Planning Services Sign Permit Review Form

Date of Submittal	Application Number	Applicant	Landowner
4/4/2022	SIGN2204-0001	Lillington Grace Church of the Nazarene	Lillington Church of the Nazarene

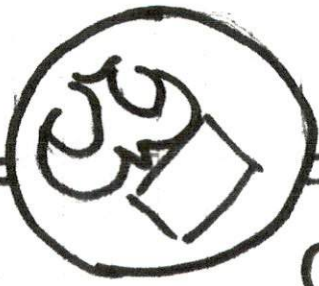
Comments	<p>More information is required.</p> <p>-Please mark on the site plan where the sign will be located. If the location is in the sign easement, please mark it.</p> <p>-Please provide the width of the sign pole covers. The required width is below:</p> <p>10.6 Sign Materials All signs shall be constructed of weather-resistant material designed expressly for signs.</p> <p>10.6.1 Pole Style Ground Signs All pole style ground signs with support(s), upright(s), bracing(s), or framework(s) that include a pole encasement shall meet the following requirements. Pole style ground signs for street signs, manufactured home park signs, interstate signs, historical identification signs, shall be exempt from the requirements of this Section.</p> <p>A. Said support(s), upright(s), bracing(s), or framework(s) shall be encased in an ornamental shell of stone, brick, ornamental metal, or similar materials, and shall be a minimum width of one quarter (1/4) of the width of the sign face; or</p>

<p>B. Said sign shall be constructed of an external support structure including stone, brick, ornamental metal or similar materials, provided that the maximum number of supports, uprights, bracings, or frameworks extending between grade and the base of the sign face shall not exceed two (2).</p>
--	---
